Sent: 18 November 2013 17:04
To: Planning
Subject: Welwyn Hatfield Council Online Planning - Comment

Application Number: N6/2013/1938/MA
Name: Peter Adderley
Address: 30 Templewood
Welwyn Garden City
AL8 7HX

Comment: I object to the amended plans for the following reasons.

Title Proposed Sections

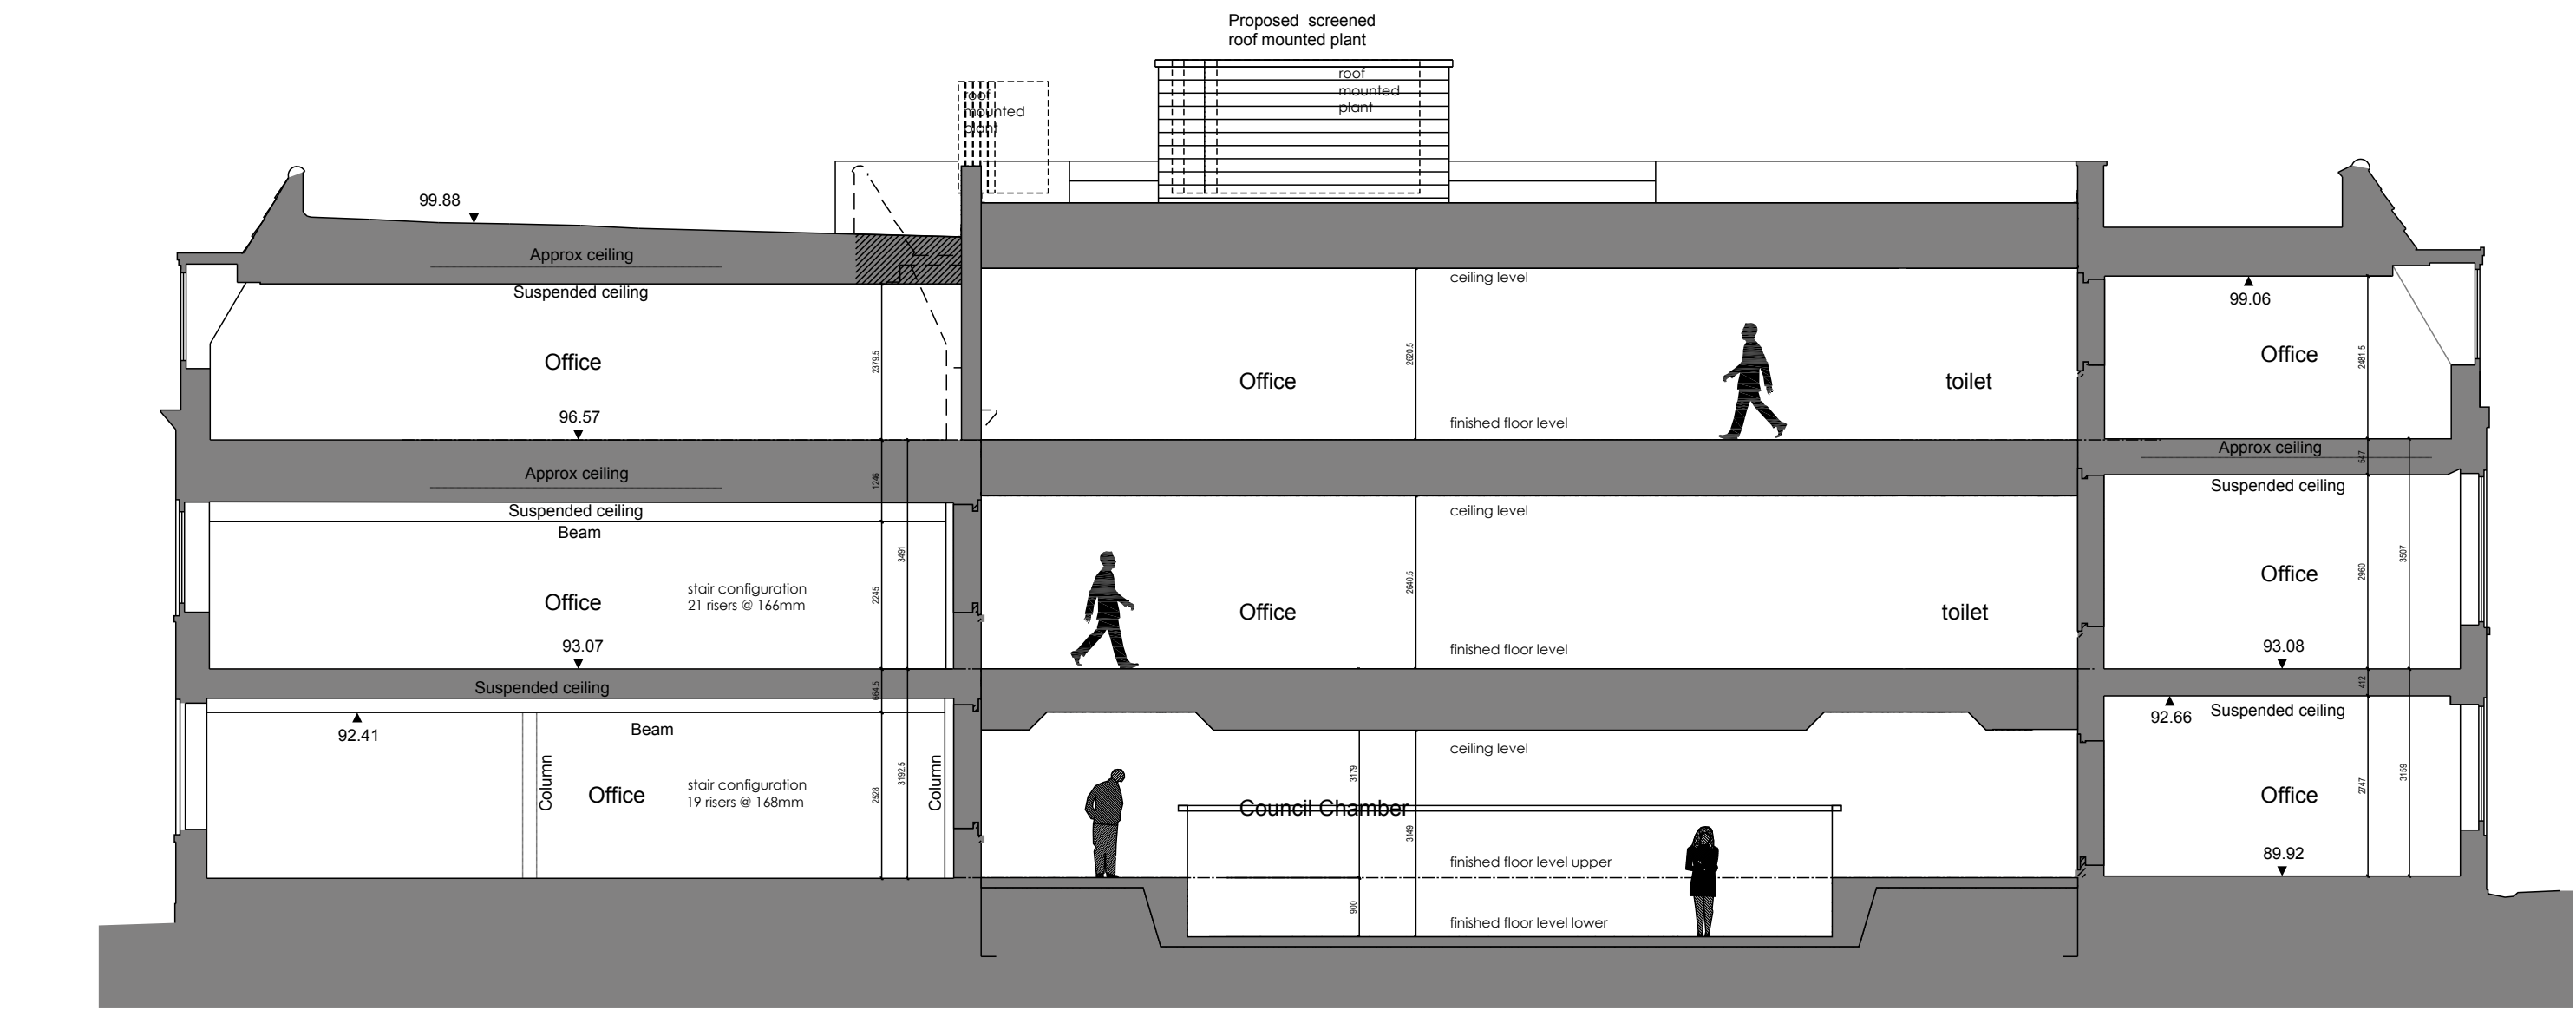
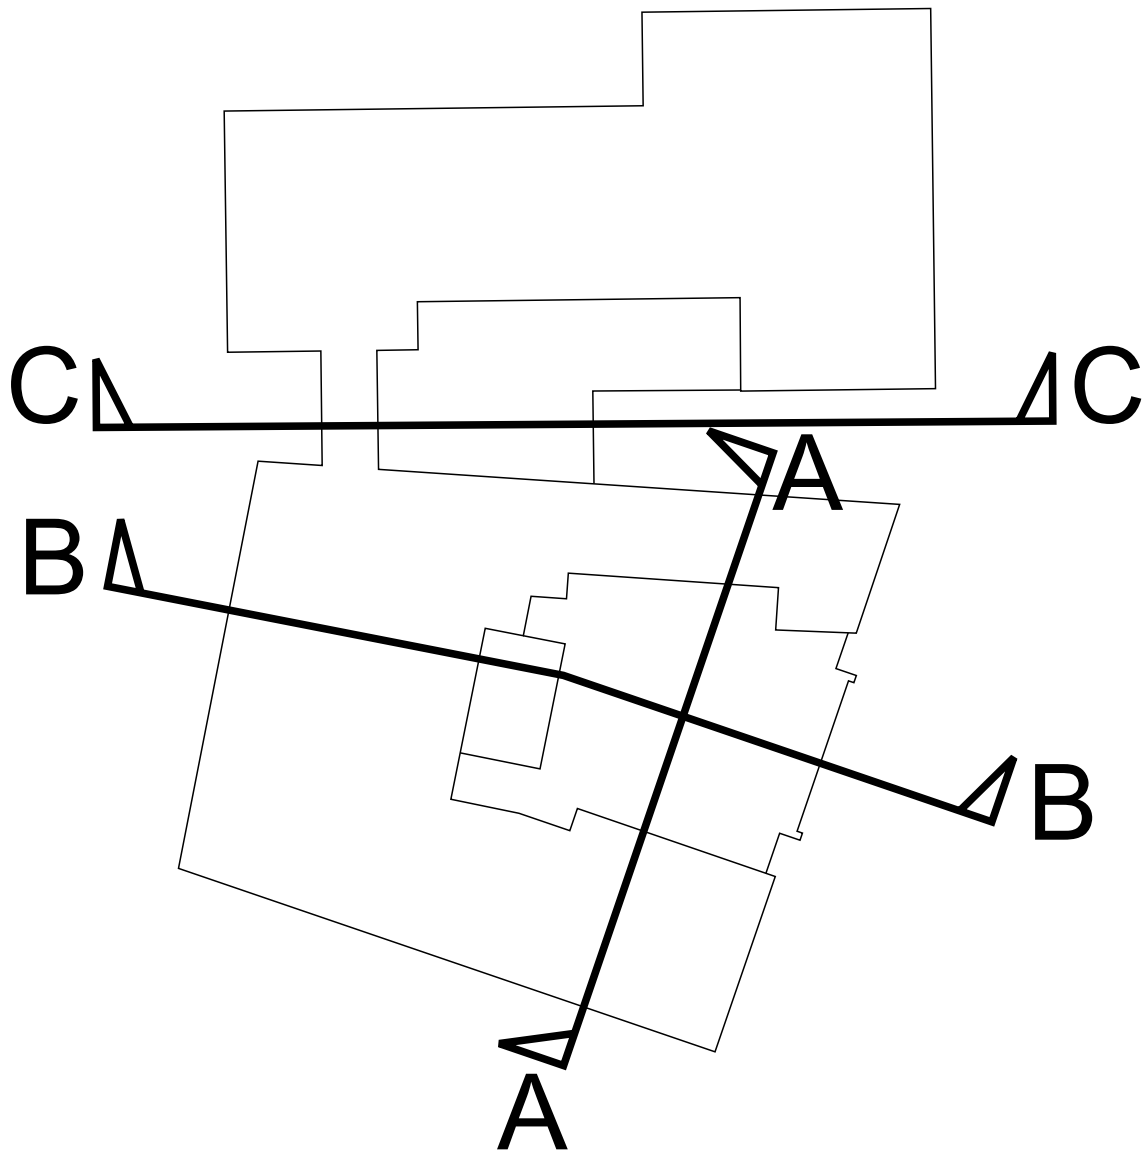
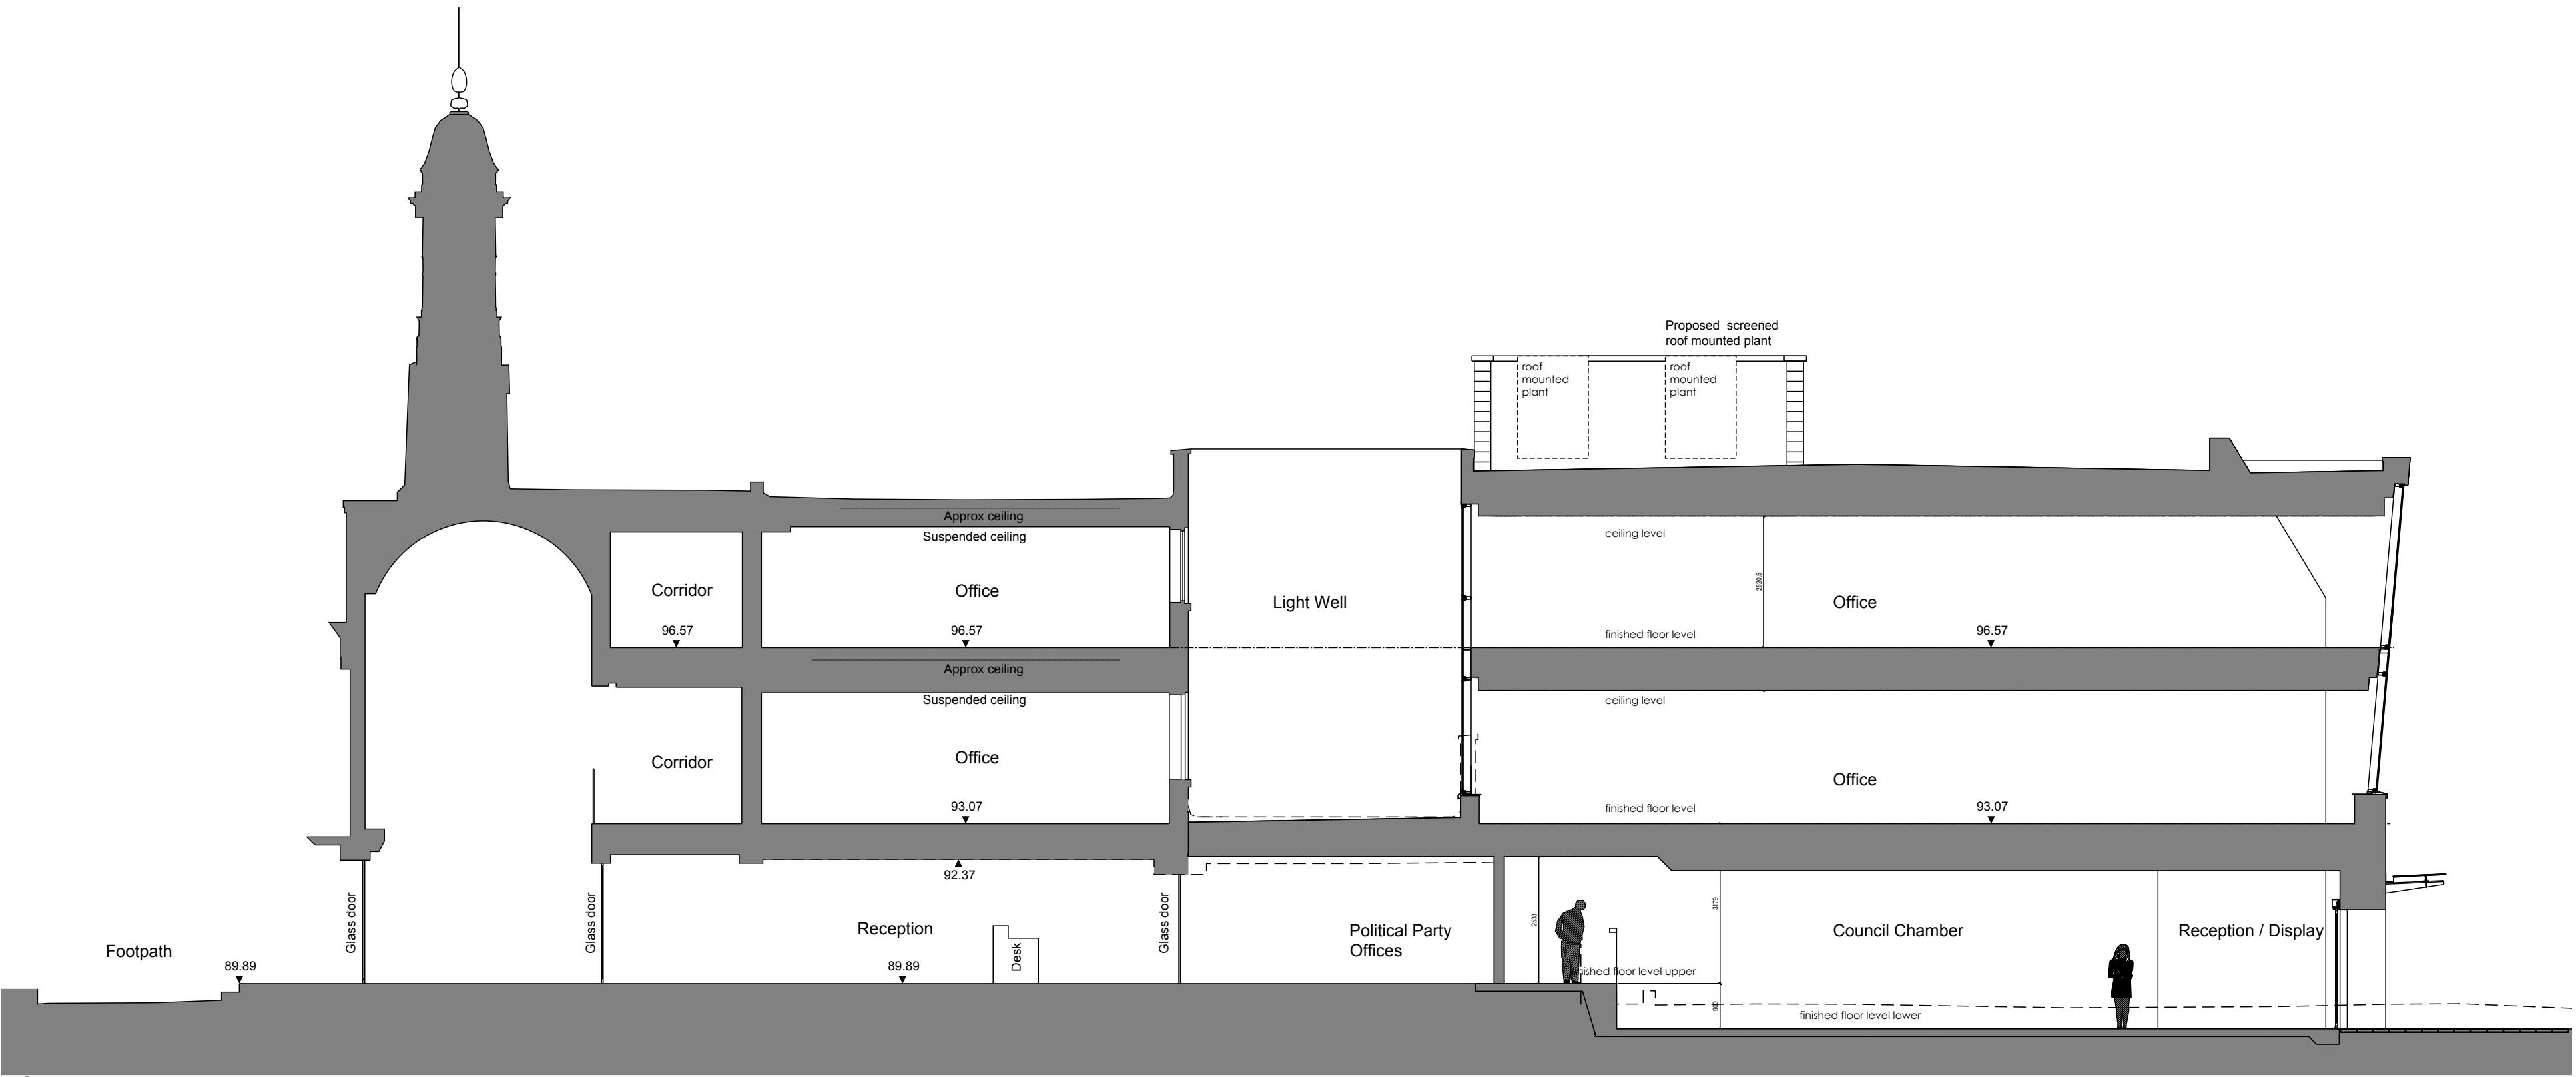
1. All my objections to the original submission still apply.
2. The amended design is no improvement on the original.
3. The design is unimaginative and crude.
4. The monolithic block is unrelated to the existing eaves line.
5. The extension is quite out of scale with the existing buildings, and out of keeping with the more intimate architectural character of the existing.
6. The Council Chamber Entrance is pompous and banal.
7. The accommodation is cramped yet still does not meet requirements.
8. The proposals are quite inappropriate for the Conservation Area, and break the Council's own rules.
